29 July 2020

TfNSW Reference: SYD19/00495/03

Client Reference: SSD 10291

**EXHIBITION OF EIS FOR ST LUKES GRAMMAR SCHOOL SENIOR SCHOOL
CAMPUS & SPORTS CENTRE - 210 HEADLAND ROAD, DEE WHY (SSD-10291)**

Figure 12 – Proposed Stage 2 *Senior School* Drop-Off/Pick-Up Bay & Car Park Access

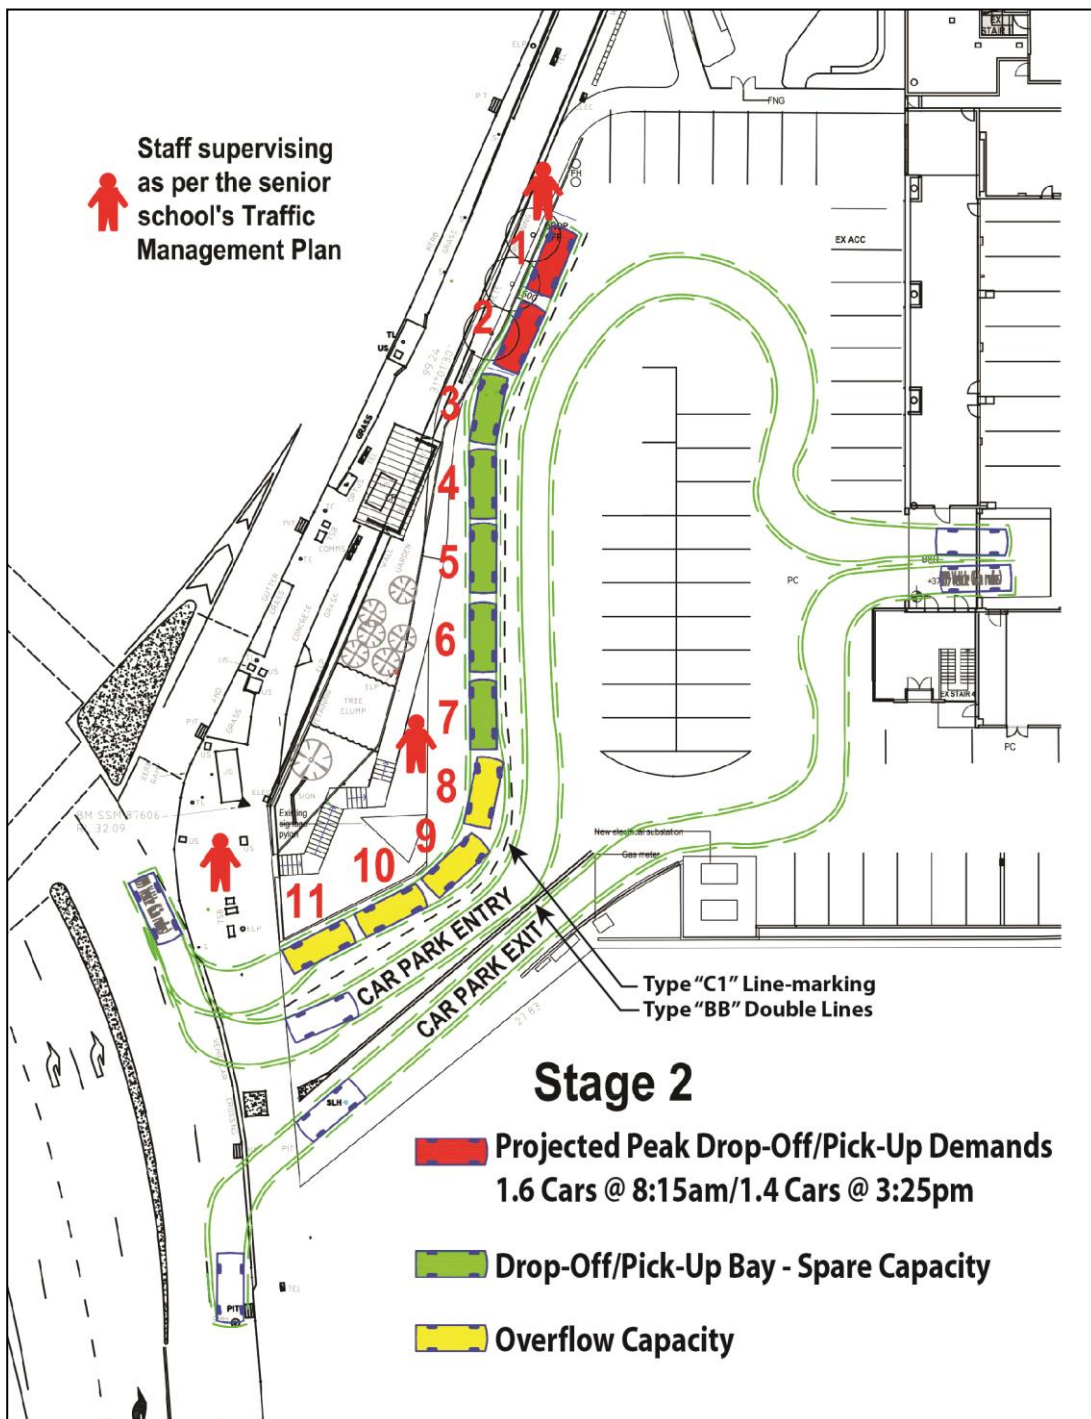
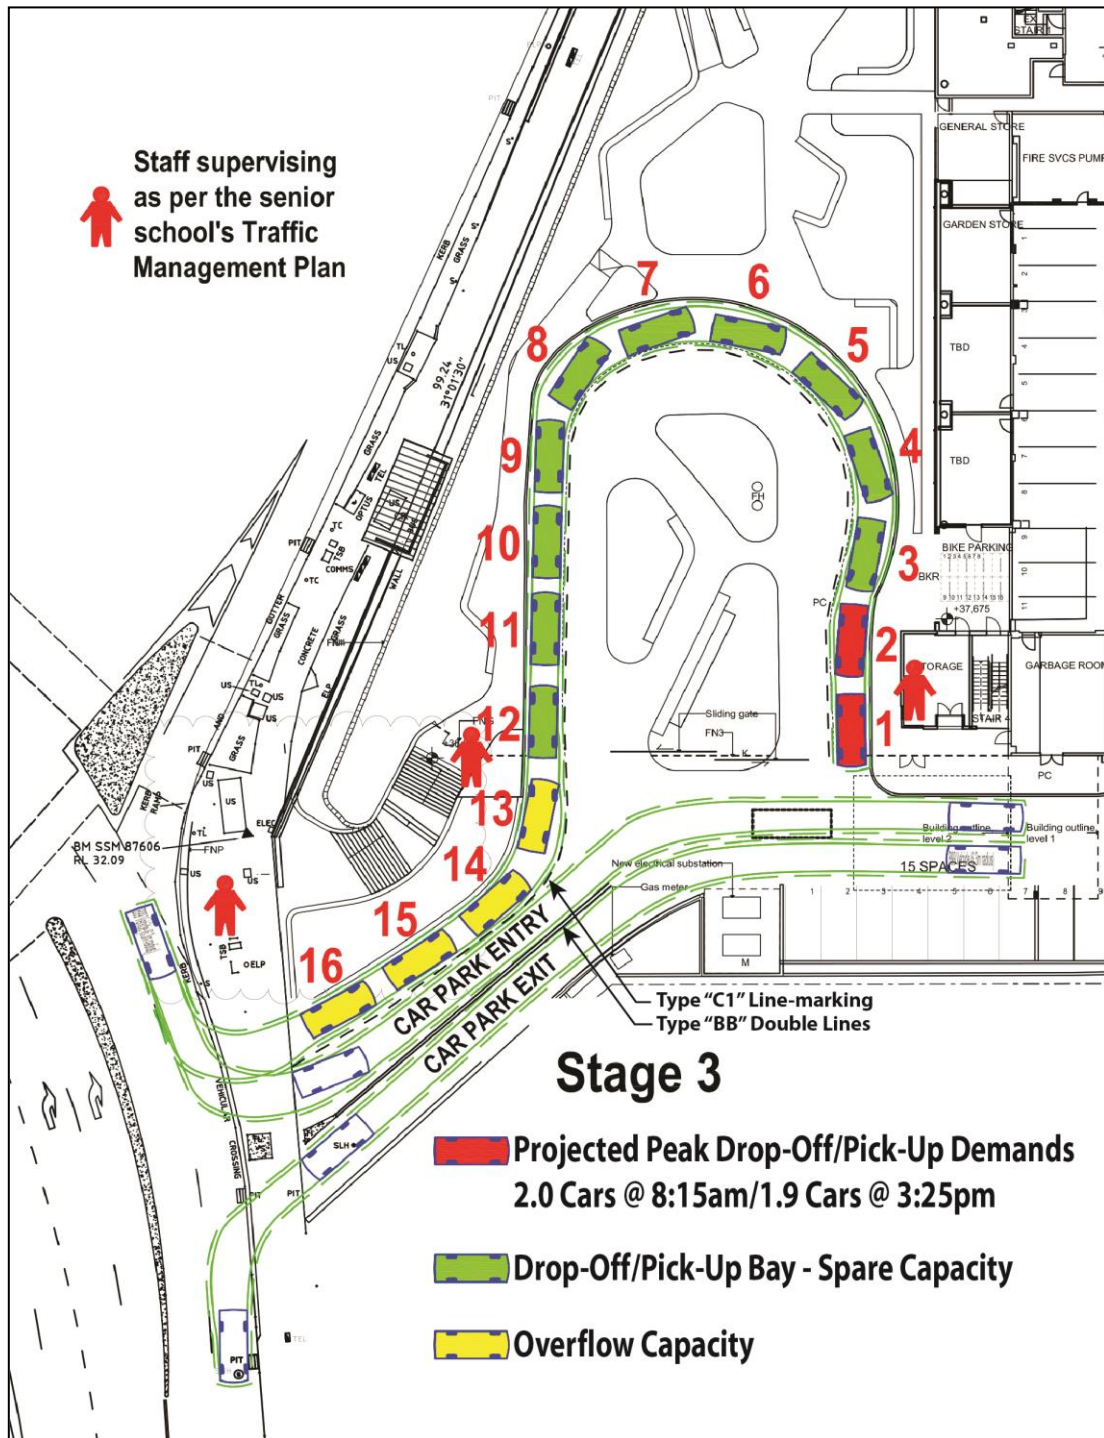
The swept path diagrams in the traffic report indicate that the manoeuvre of a HRV encroaches the pickup and drop-off area. In particular during Stage 2, these pickup and drop-off spaces will be likely occupied by the vehicles associated with the Officeworks during off-peak period. This will potentially obstruct the vehicle movement on site and result in potential vehicles queuing back to Harbord Road.

Recommendation

The Proponent is requested to revise the design of the car parking area allowing manoeuvre of a HRV without any encroachment.
